25 May 2022

TfNSW Reference: SYD21/00188/04

Department's Reference: SSD-14378717

**RESPONSE TO SUBMISSIONS FOR TELOPEA CONCEPT PLAN & STAGE 1A
RESIDENTIAL, RETAIL, CHILD CARE & AGED CARE - ADDERTON ROAD, TELOPEA**

TELOPEA URBAN RENEWAL PROJECT
MASTERPLAN
INTERSECTION PLAN
SHEET 3

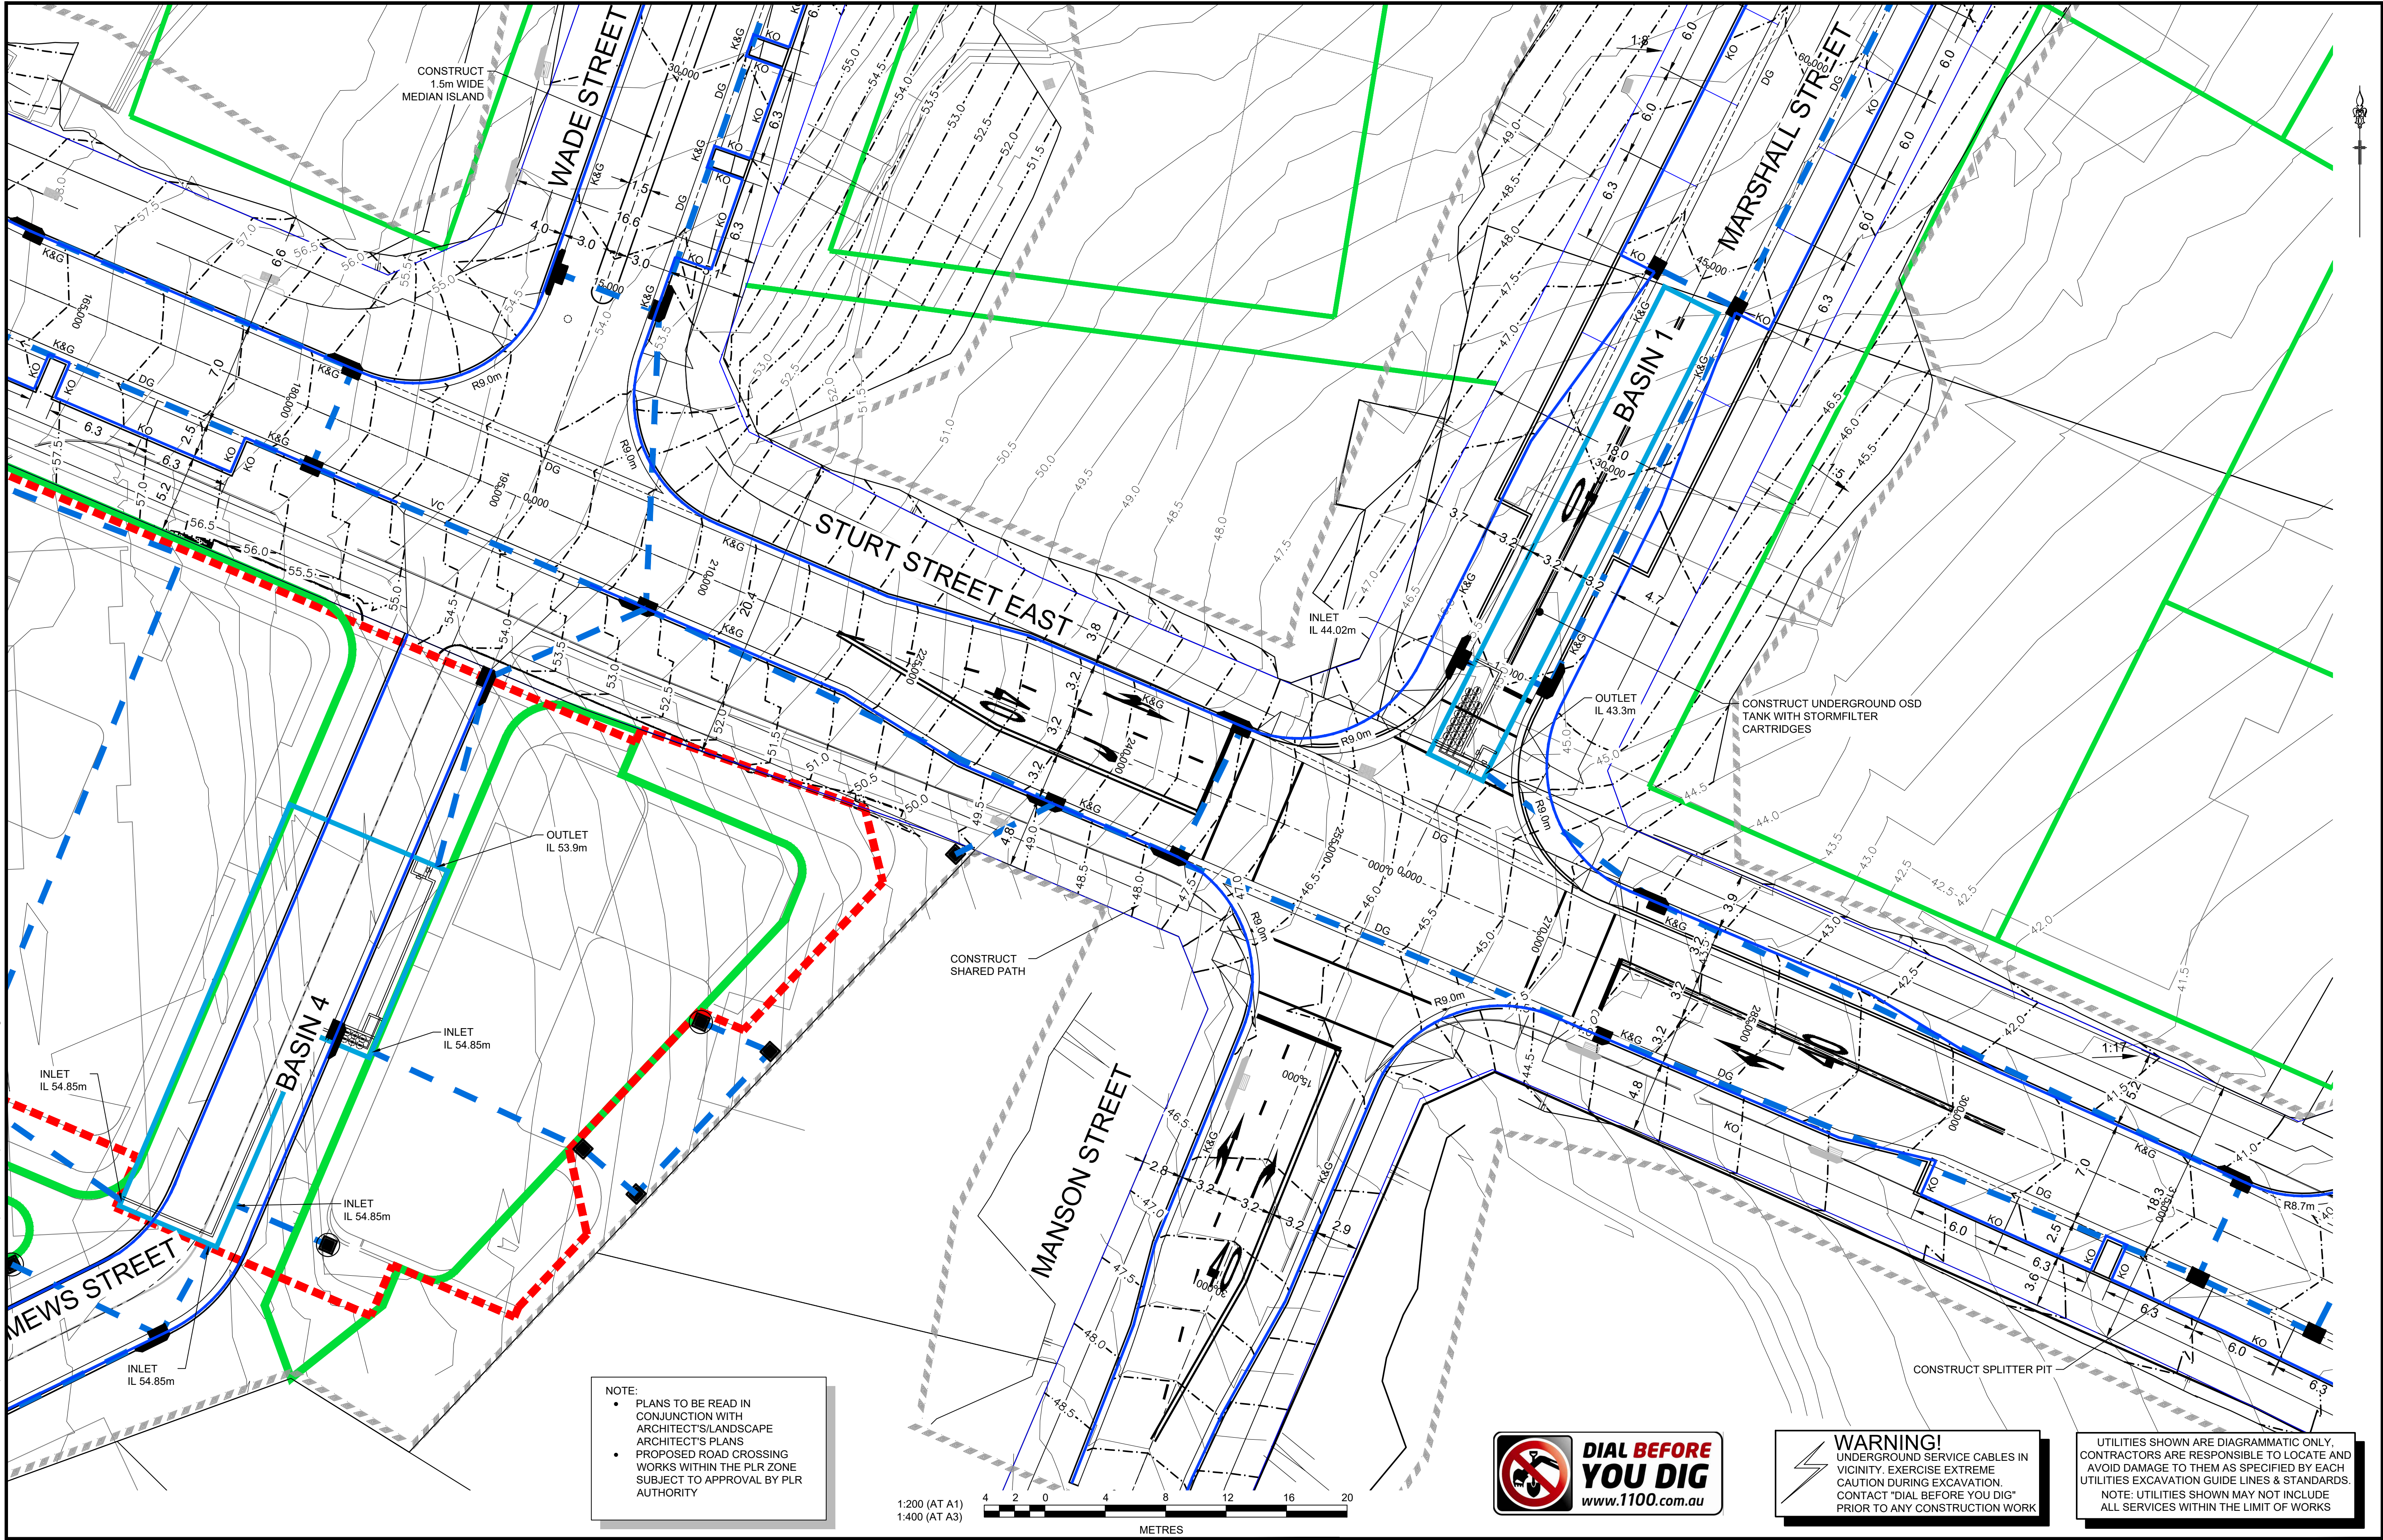
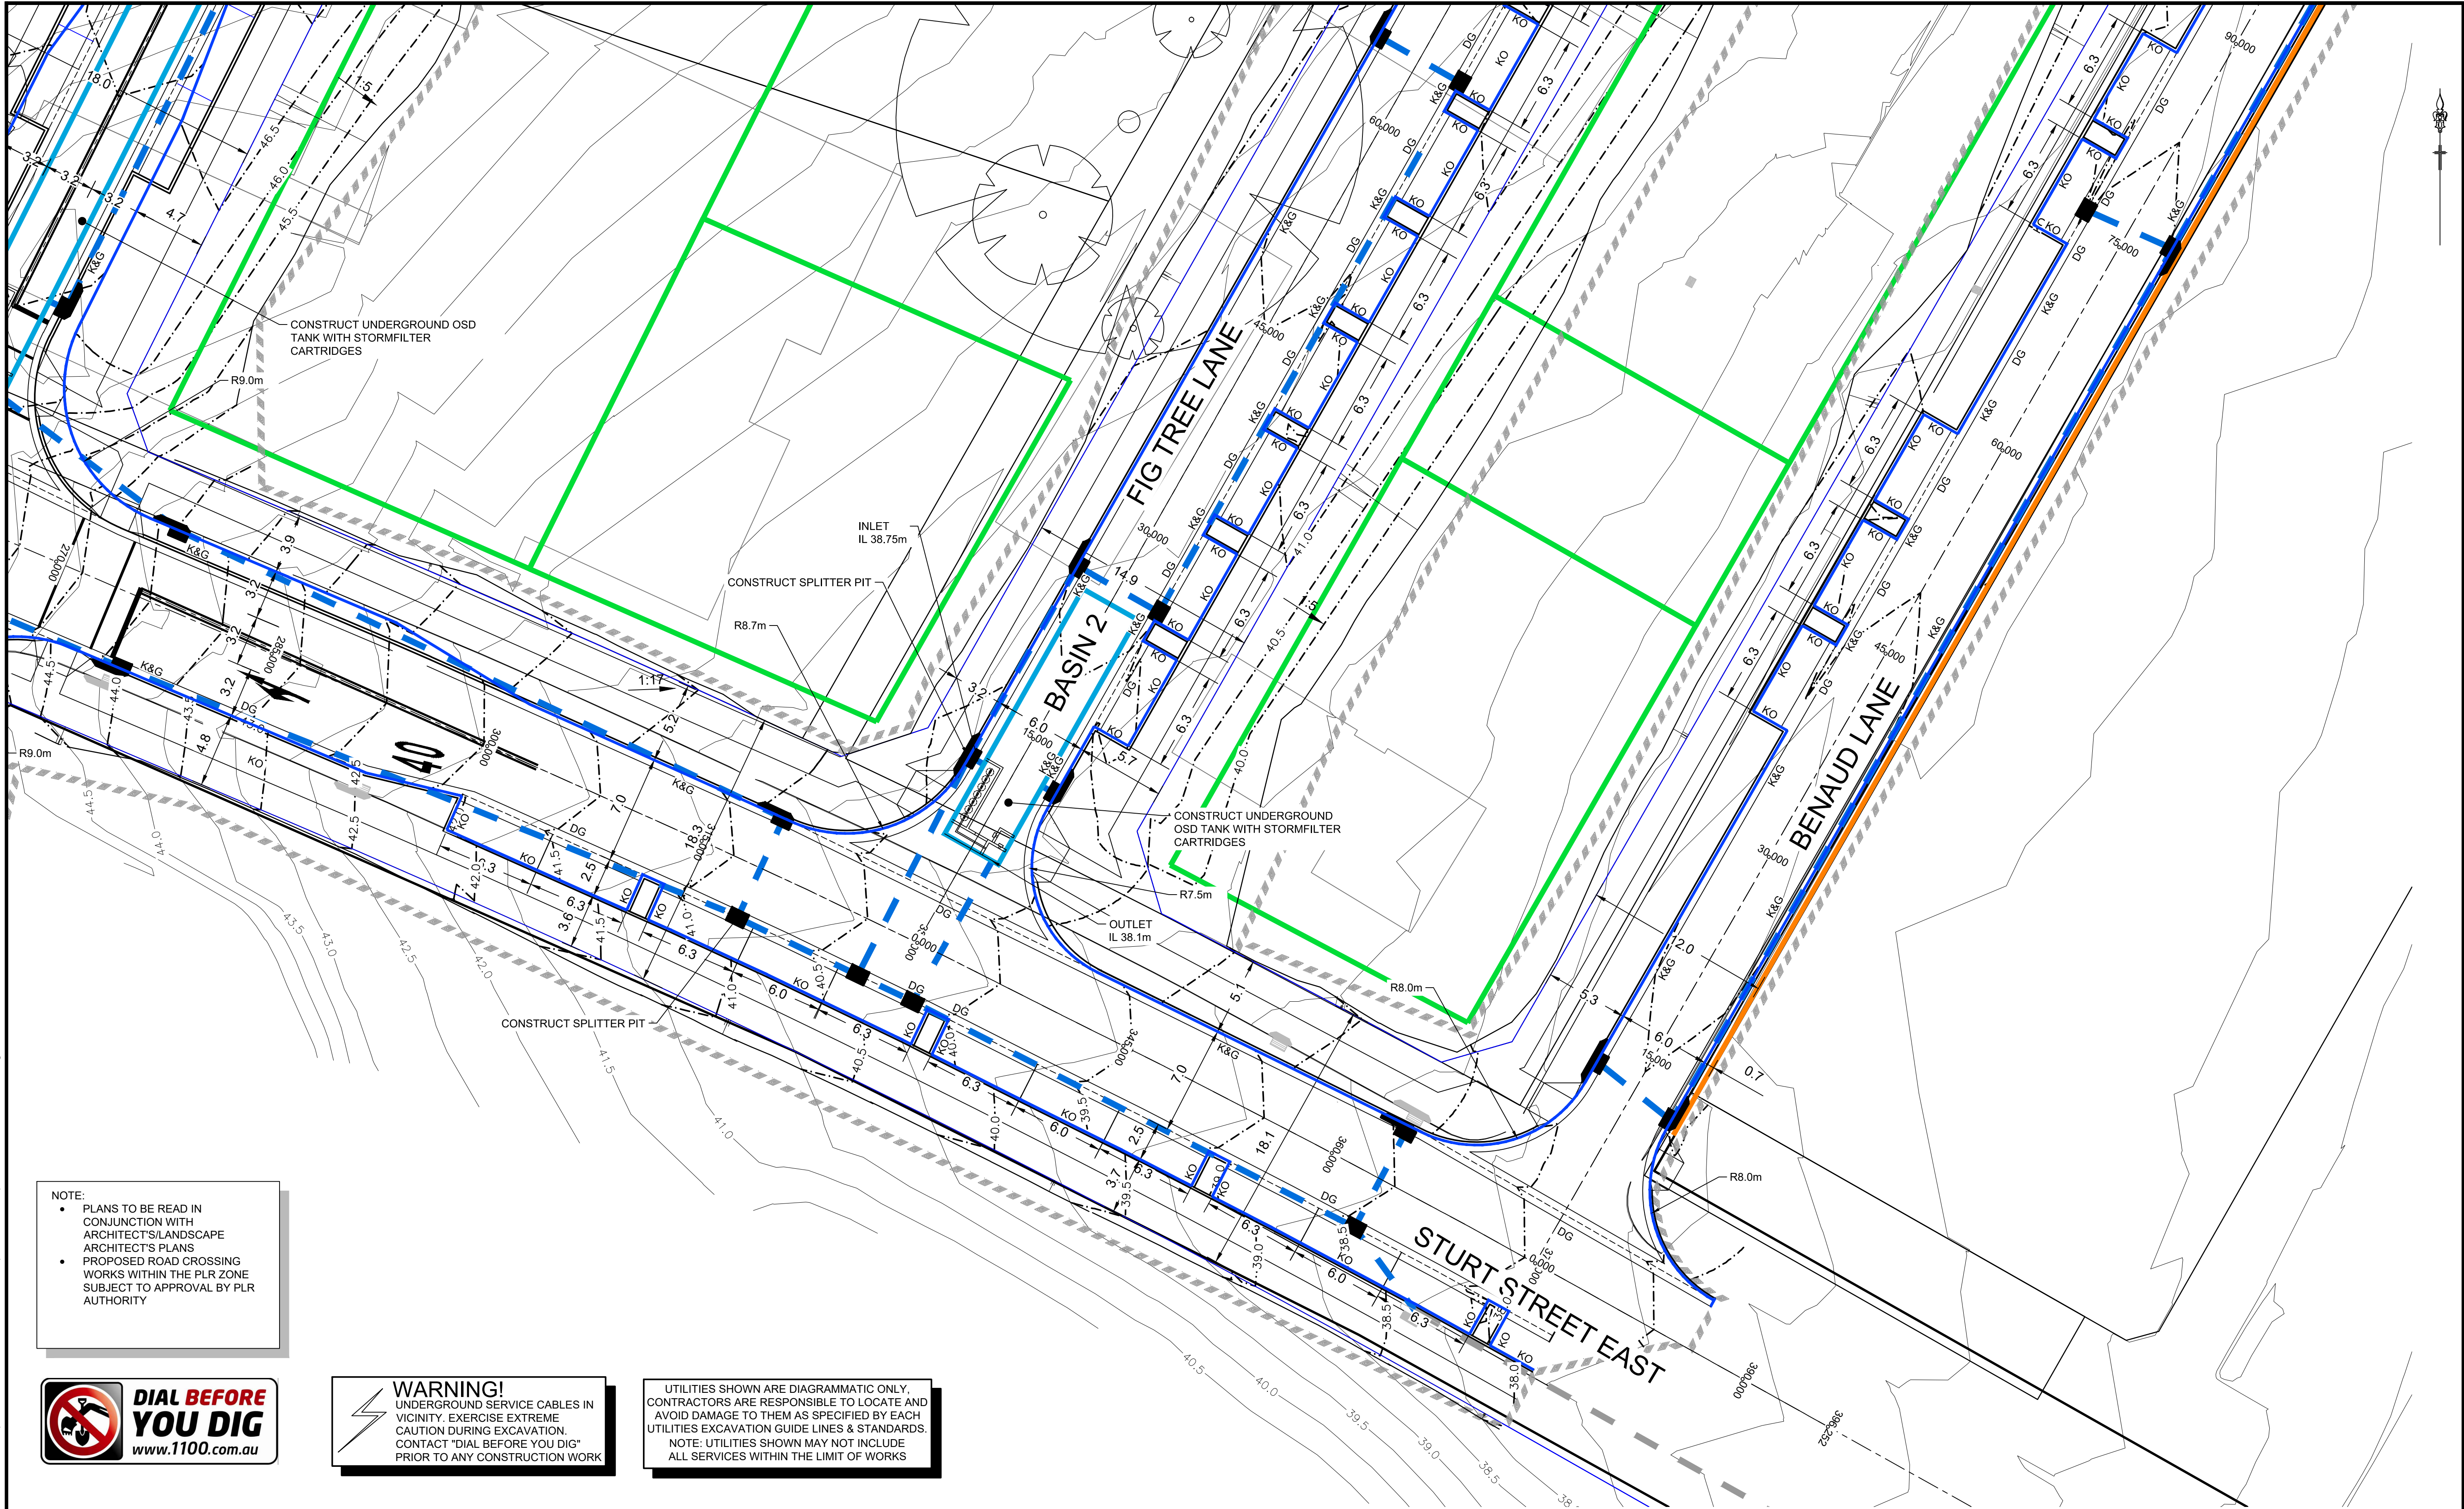
2. Comment 5 in the previous TfNSW for SSD-14378717 dated 20 December 2021 has not been adequately addressed. Relocation of the proposed TCS on Adderton Road/New Link Road is be reflected in resubmitted civil design plans and amended SIDRA modelling.
3. The TfNSW concerns regarding the proximity of the proposed intersection to the mid-block signals near Roberts Street is still a concern and has not been addressed.
4. New Link Road is proposed to be a single lane on approach. There are conflicting

pedestrian crossings and required pedestrian protection time will result in no traffic coming out of the side street (Sturt Street). TfNSW requests two lanes on this approach.

7. There is a proposed 3% crossfall gradient on both sides of the New Link Road verge that is not aligned to the light rail alignment (2.5% crossfall gradient to the south). Amended civil plans should be submitted showing the grade pavement at crossing is flush with the light rail.

11. The footpath and pedestrian crossing are not aligned to the location of the Overhead Wire pole JC5+236 which is a potential *Disability Discrimination Act 1992 (DDA)* compliance issue. The footpath and pedestrian crossing should be amended in resubmitted civil plans.

15. The stop line on the intersection layouts for Adderton Road/New Link Road should be located as close to the intersection as possible to minimise inter-green time and improve sight distances.
